From: Ross Leal
Sent: 05 April 2018 10:30
To: [REDACTED]
Subject: WA/11/18/DOC - Approval of Reserved Matters - Progress Garage, Yapton Lane, Walberton

From: Paul Cann
Sent: 27 February 2018 16:47
To: Planning.Responses
Subject: RE: Planning Consultation on WA/11/18/DOC

Description of Works: Approval of details reserved by condition imposed under WA/29/17/RES relating to conditions 3-schedule & samples of materials & finishes, 4-surface water drainage, 5-maintenance manual & details of SUDs, 7-cycle parking, 8- site set up during construction & 9-scheme to deal with risks of contamination.

From: Matthew Kennett
Sent: 28 February 2018 16:23
To: Planning.Responses
Subject: RE: Planning Consultation on WA/11/18/DOC

Scale 1:200	Drawn By SPB	Checked By MJA	Approved By MJA
Date April 2018	Drawing No. 2017-D1337-001		Rev. A

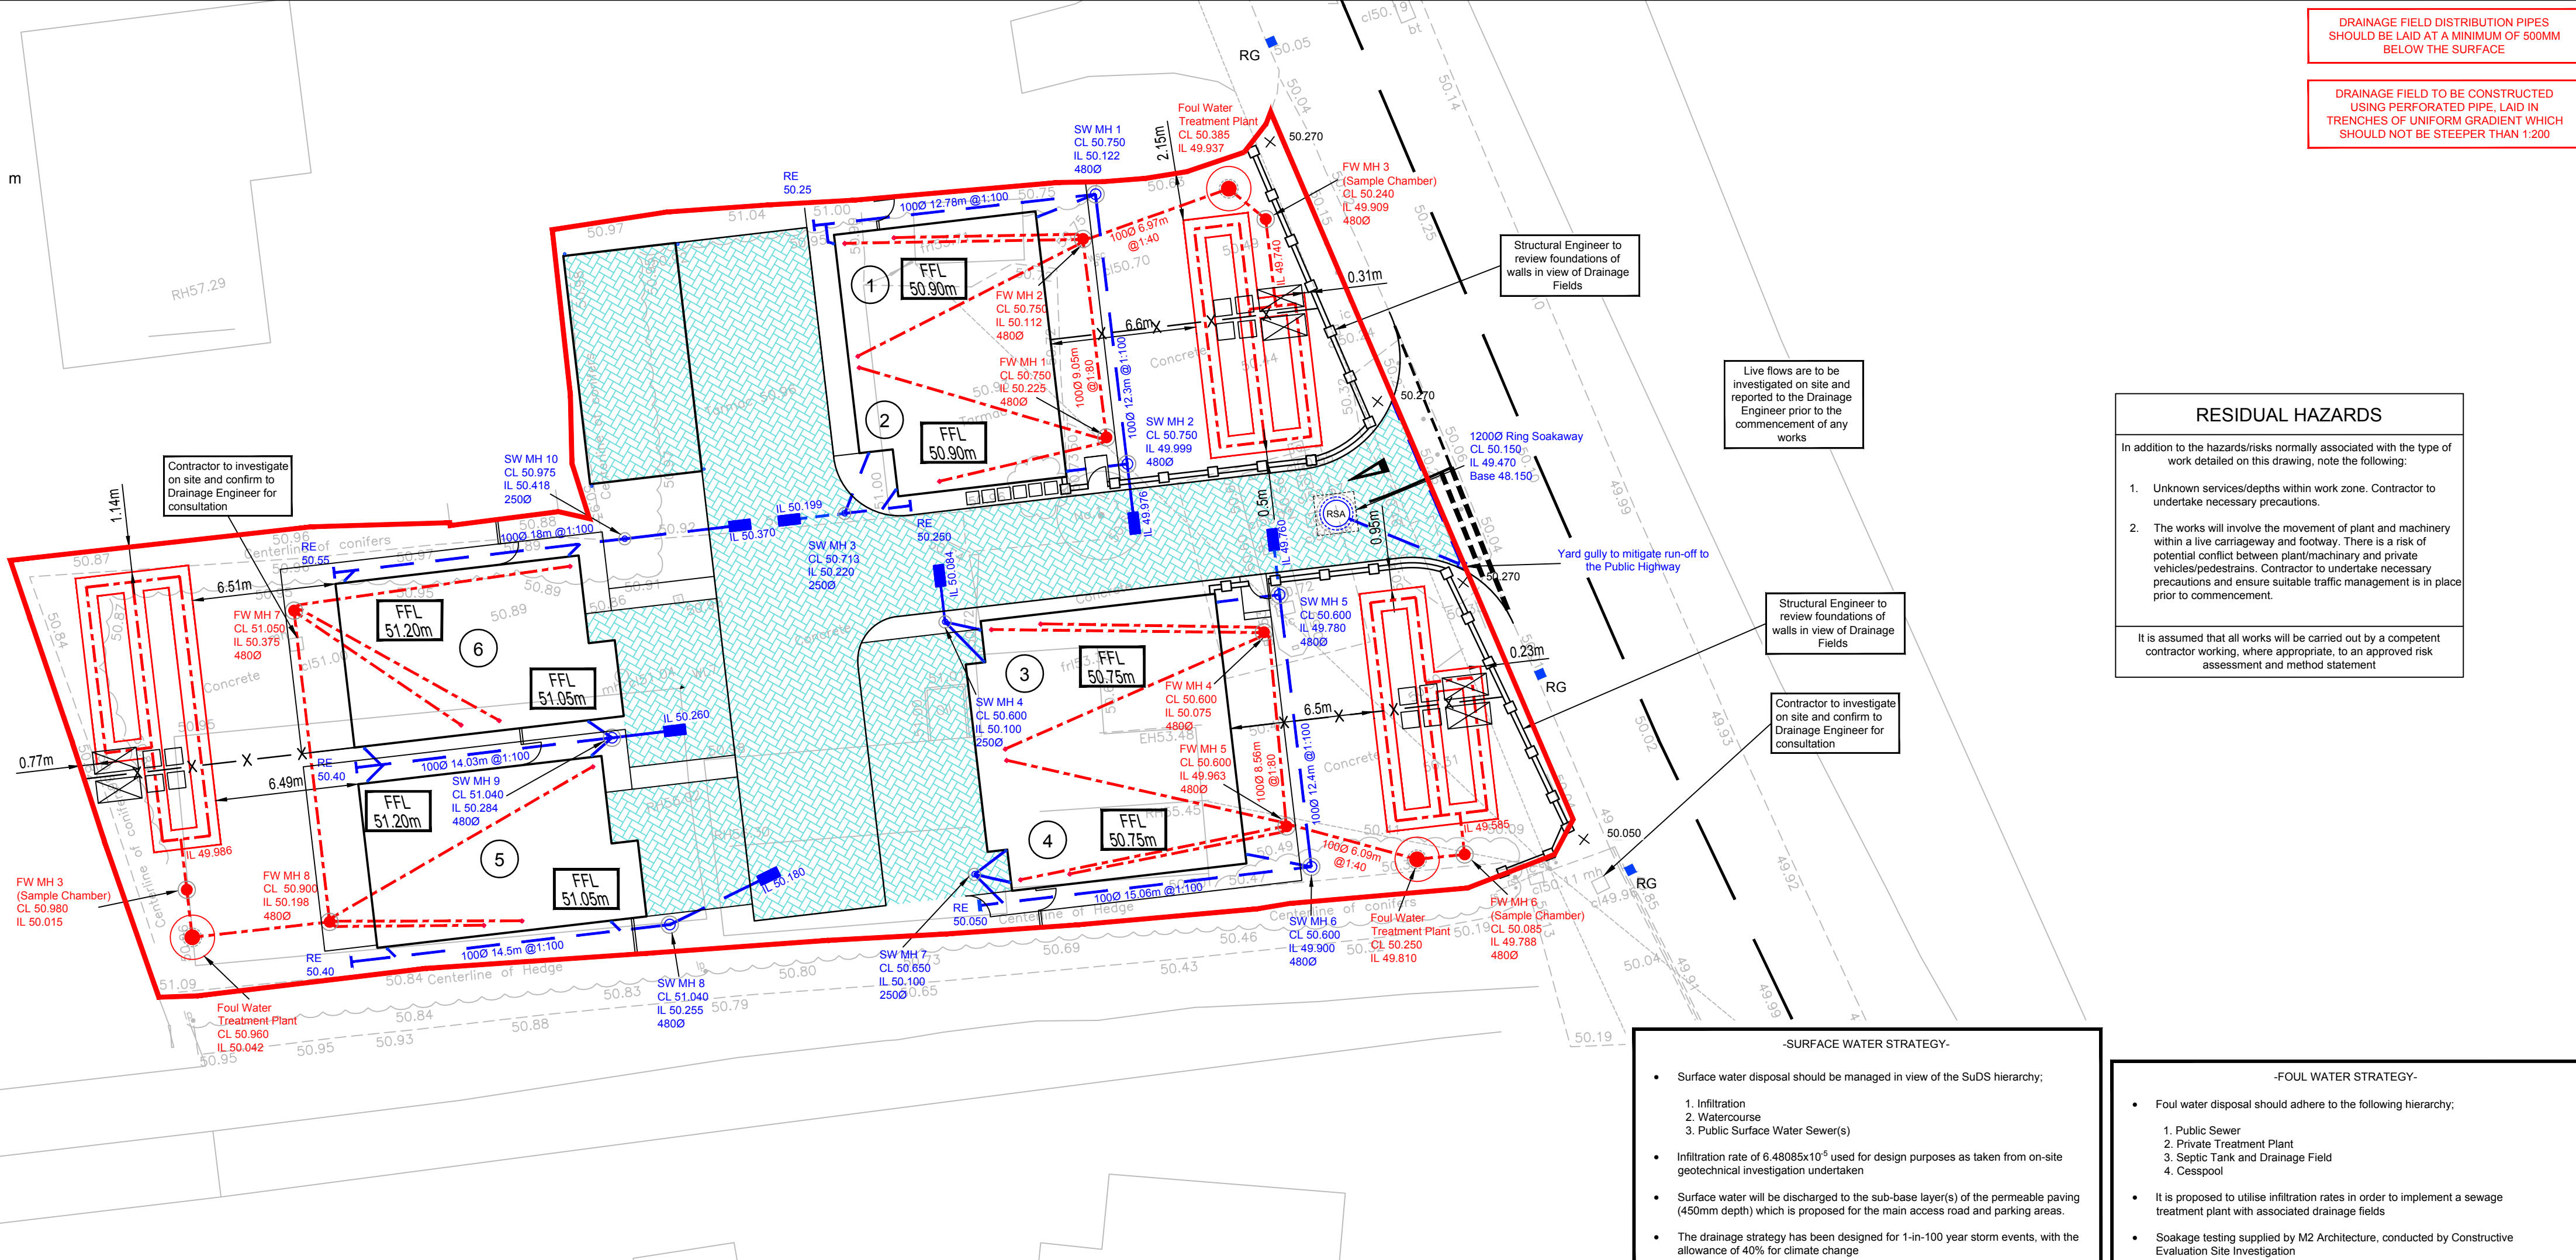
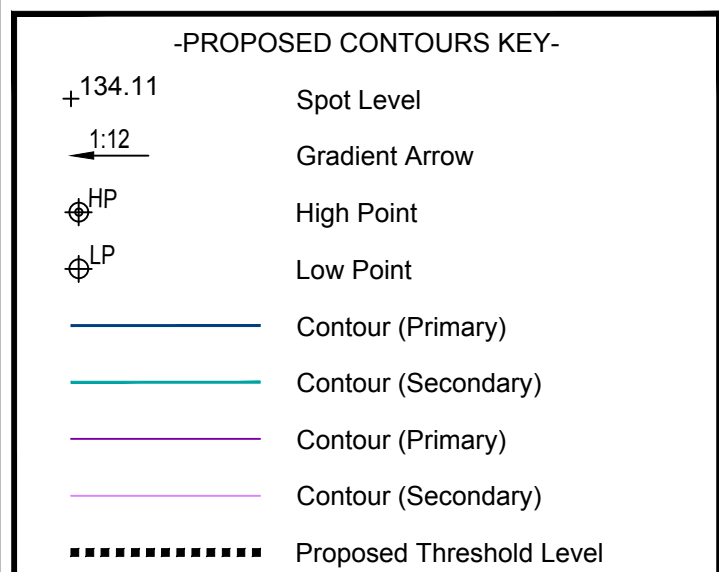
1. Winter groundwater monitoring data and winter percolation testing data to BRE365 has not been supplied. Groundwater monitoring was carried out in April 2017 but this is outside the recognised winter period. These aspects are critical to the design, and the proposals cannot therefore be considered further until such time that the data is available and been considered.
2. Full construction details for the drainage elements will also be required, together with hydraulic calculations to ensure the 1 in 100 year storm event + climate change allowance can be stored within the system.
3. The drainage layout will need to include all relevant levels ie. finished surface levels/permeable paving base levels/pipe invert levels/pipe diameters/Pipe gradients/manhole cover levels, etc.
